Project: 1904 Bellamah Ave NW
DRB Project Number: PR-2022-007153 / SI-2023-01646 – SITE PLAN

Subject: DFT Resubmittal 2
Date: 01.19.2024

LANDSCAPE PLAN INCLUDING FUTURE STREETScape DESIGN
LP102

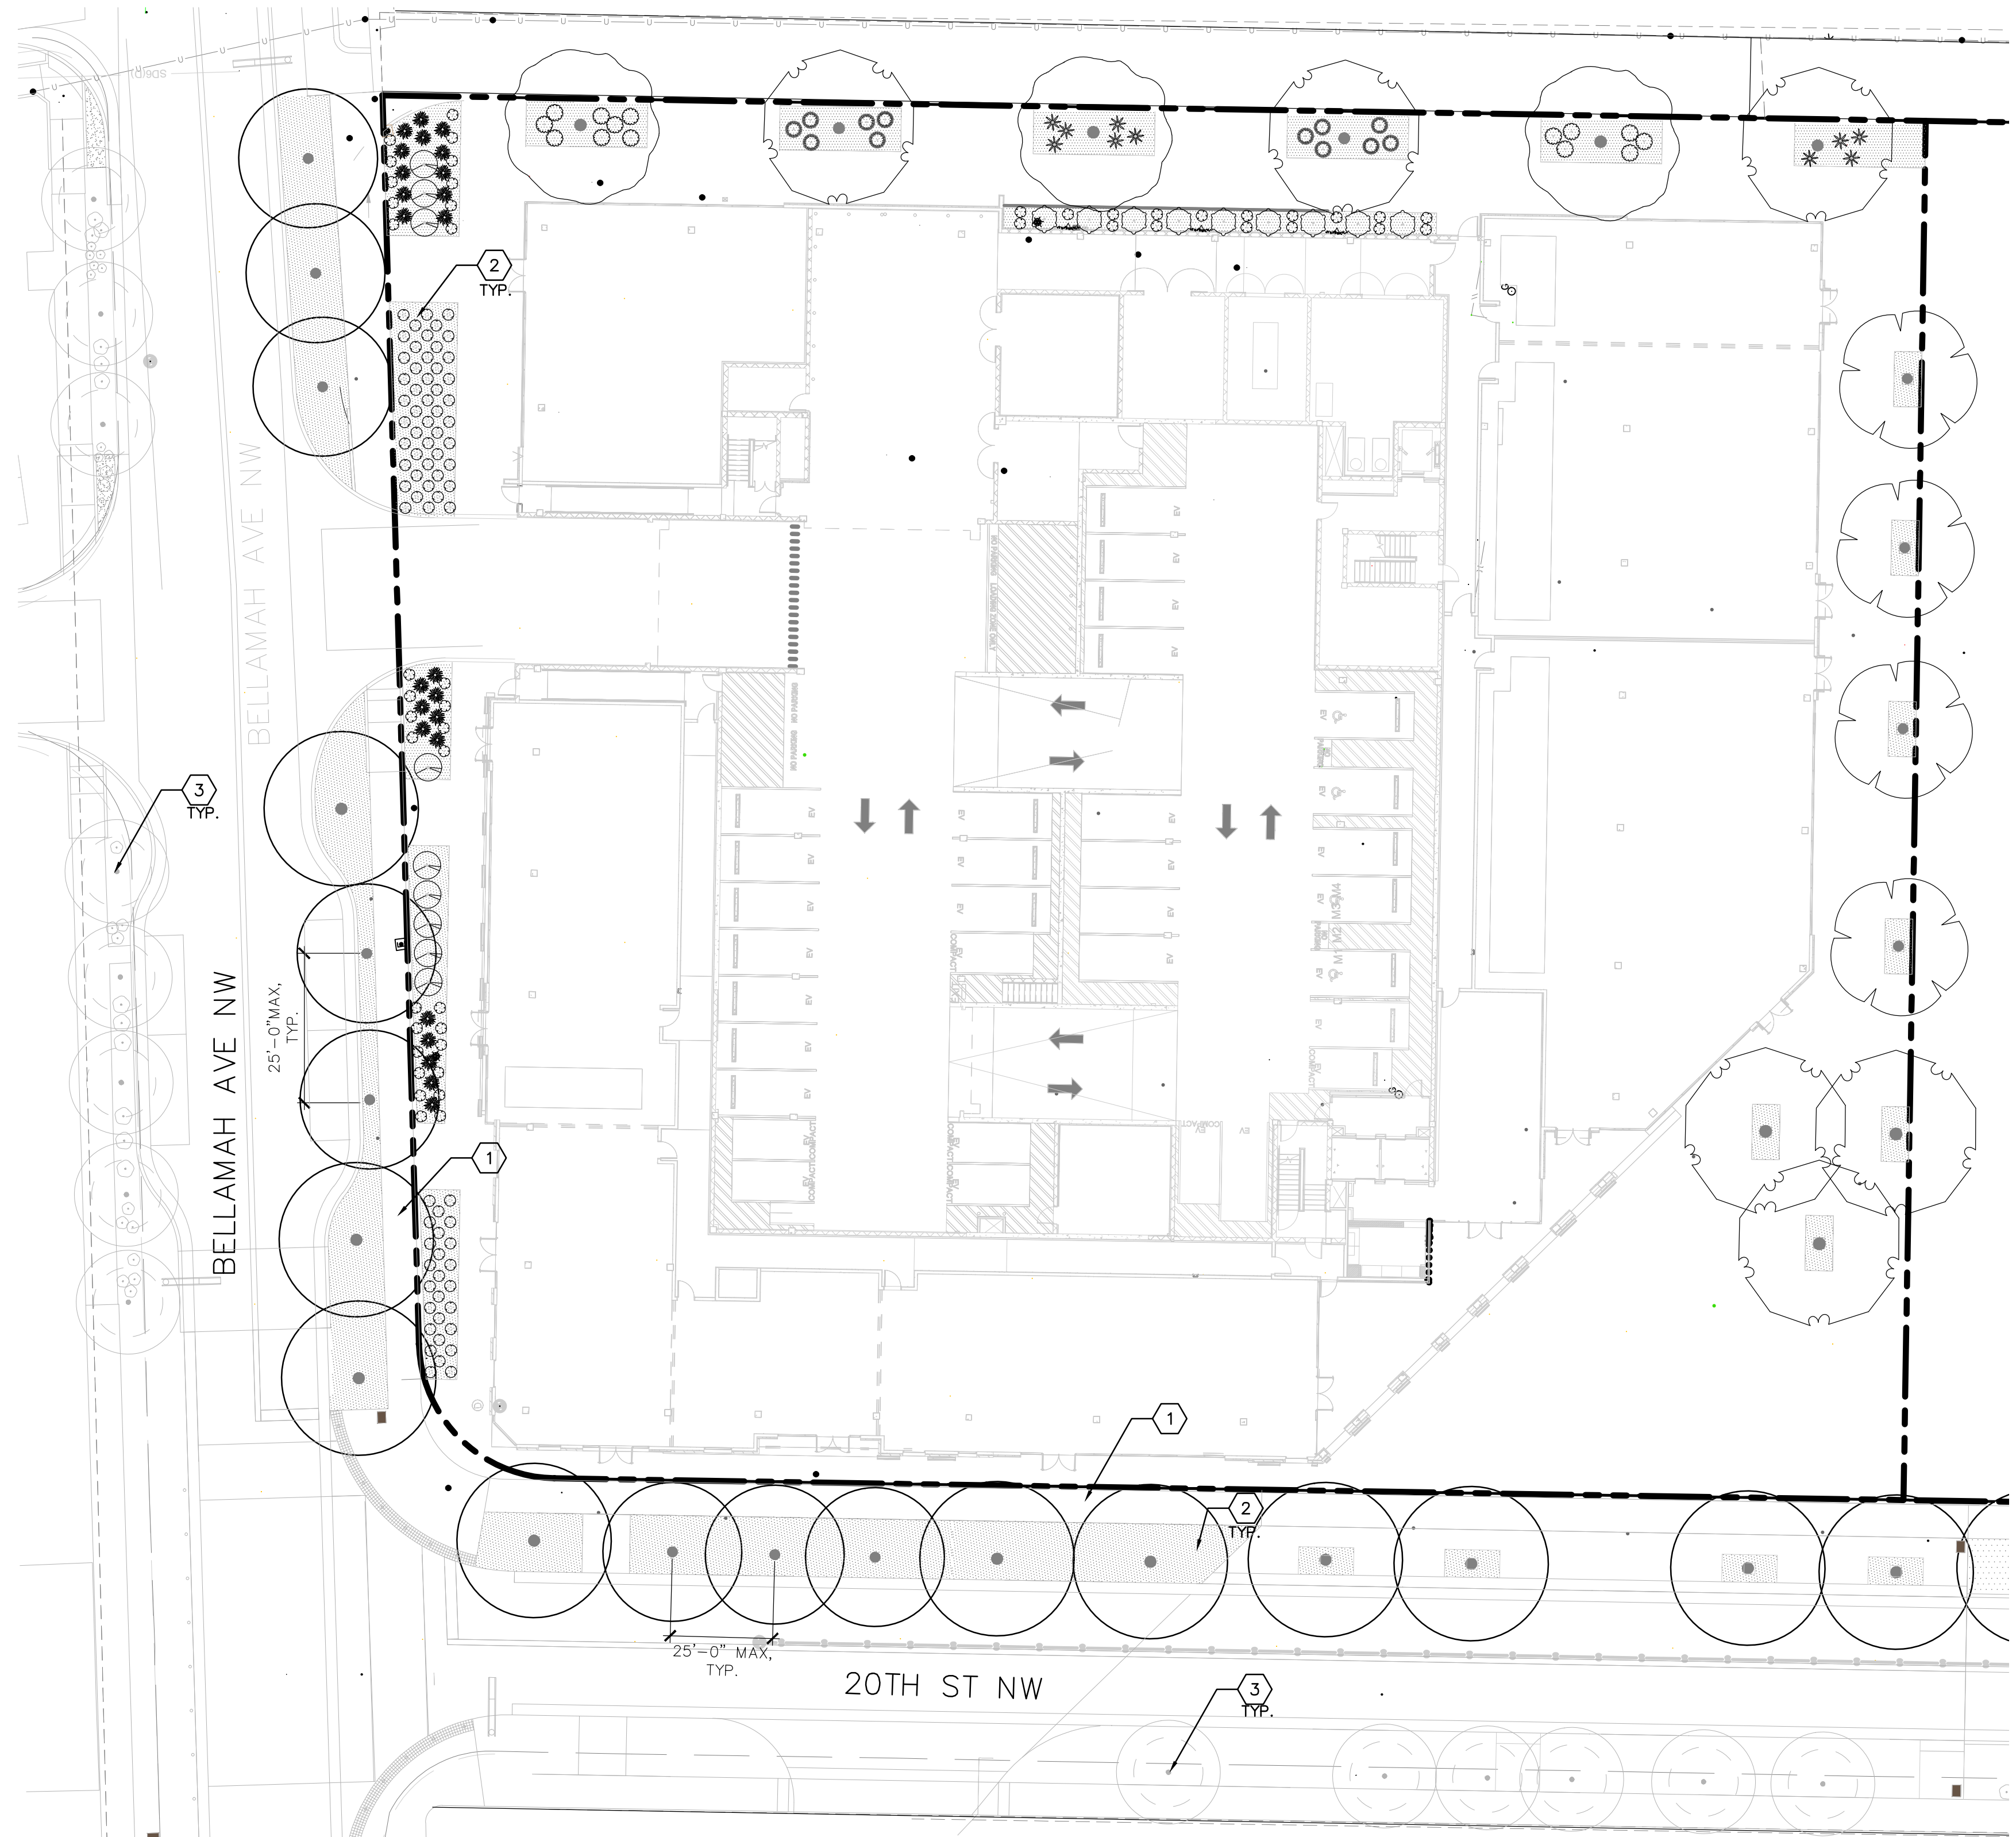
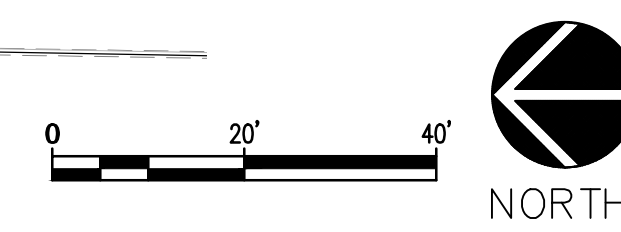
6	5-3(D)(3)(b) Network of Pedestrian Walkways 4. Pedestrian walkways shall be installed along any street-facing façade with a pedestrian entrance of a building containing any of the following development: <ul style="list-style-type: none"> a. Mixed-use or non-residential development in any Mixed-use zone district. b. Development of uses in the Civic and Institutional or Commercial categories in Table 4-2-1 in any Nonresidential zone district. c. Pedestrian walkways required by this Subsection shall meet the standards of the DPM, except where Table 5-3-1 requires a wider walkway. Please reference IDO Table 5-3-1 Required Walkway Width; provide building overall footprint to ensure compliance.	The building footprint is 49,426 SF, noted in site data. 10'-0" wide walkway required. 10' + 6' wide walkway provided along Bellamah and 15' wide along 20 th St.	Page 17
7	Per IDO 5-3(D) On-site Pedestrian Connections All multi-family residential, mixed-use, and non-residential development shall comply with all of the following standards. 5-3(D)(3)(a) General <ol style="list-style-type: none"> 1. For the purposes of this Subsection 14-16-5-3(D)(3), the building's overall footprint will be considered the area for calculation of sidewalk width. A collection of smaller buildings linked by common walls will be considered as 1 building. Refer to note above regarding Network of Pedestrian Walkways. 2. Where primary pedestrian entrances are located adjacent to a public sidewalk, the width of the public sidewalk may be included in the calculation. Please note that public sidewalks may be included in calculation above. 3. Shade trees along required pedestrian walkways are required 	Street trees in the ROW will be installed as part of the City's Sawmill Streetscape Improvements project and will meet these requirements of 25'-0" O.C. We have overlaid the proposed design on sheet LP102. Please reference COA Project Number 617579.	Page 15

A1 TREE PLANTING ON FLAT SURFACE
NOT TO SCALE

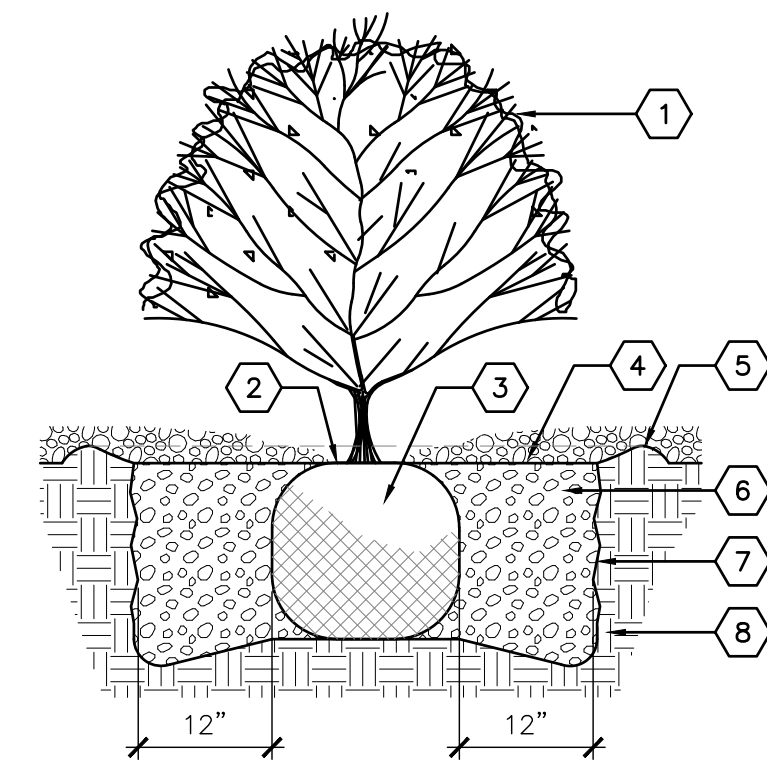
<p>5-6(C)(5)(e) Organic mulch is required as ground cover under trees within a 5- foot radius around the tree trunk, but not directly against the trunk. In these areas, weed barrier fabric is prohibited. (See figure below.)</p> <p>Update tree planting detail on Planting Details and Schedule (LP501) to show organic bark mulch at 5' radius with no filter fabric.</p>	A3/LP501.	
18	<p>Landscape Plan (LP101) & Landscape Calculations shows there is 153 SF of landscape proposed in the right-of-way. Please note:</p> <p>5-6(C)(9) Planting in or over the Public Right-of-way</p> <p>5-6(C)(9)(a) All planting of vegetated material or installation of any landscaping, buffering, or screening material in the public right-of way shall require the prior approval of the City. The property owner shall be responsible for the maintenance, repairs, or liability for all the landscaping placed in or over the public right-of way. Please also reference IDO 5-6(C)(9)(b) and 5-6(C)(9)(c).</p>	<p>No plant material will be provided in the ROW landscape area as part of this project. The landscape in the ROW will be installed as part of the City's adjacent Sawmill Streetscape project. See sheet LP102 and COA Project No. 617579 for reference. There are no utility easements on the property. The plan has been updated to reflect this.</p>	Page 14,15

EXTERIOR ELEVATION - EAST

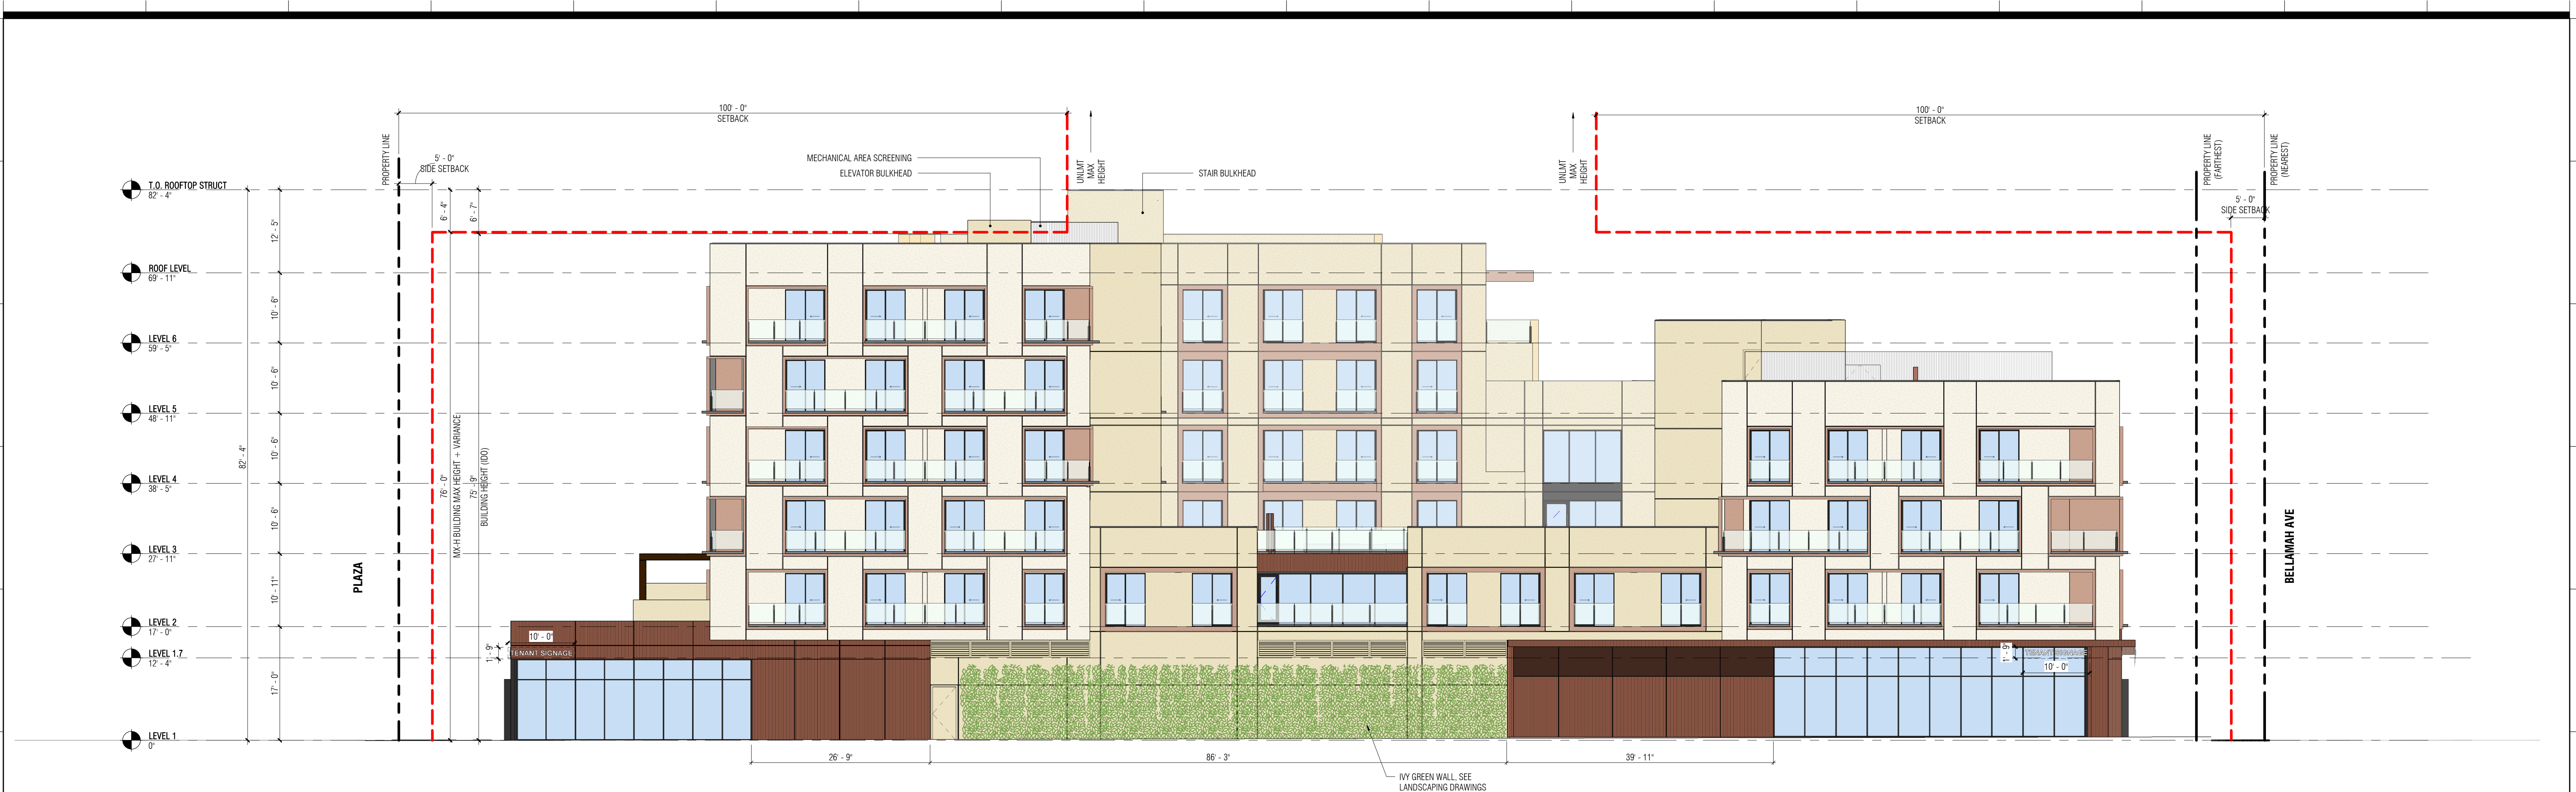
4	3-4(M)(5)(d) Façade Design in Mixed-use and Non-Residential Zone Districts For all development except residential and industrial development, each street-facing façade shall contain 25 percent or more of its surface in transparent windows and/or doors. Provide calculations for west elevation and north elevation.	Glazing percentage for street-facing façade noted on elevations sheets	Page 22-24
5	IDO 5-3(D)(2)(b) Sidewalks in Mixed Use Development: Reference DPM 7.2.29 for Sidewalk/landscape buffer widths. 20 th St NW and Bellamah Ave NW are both urban local roads and require a 5' sidewalk and 4'-6' landscape buffer. No landscape buffer is being shown along 20 th St. NW. Show compliance (minimum 4' landscape buffer) along Bellamah. Please also note.	Dimensions were added to the Site Plan. 20 th Street is being redeveloped by DMD for the 20 th Streetscape project and addresses landscaping along this roadway	Page 17, 14, 169
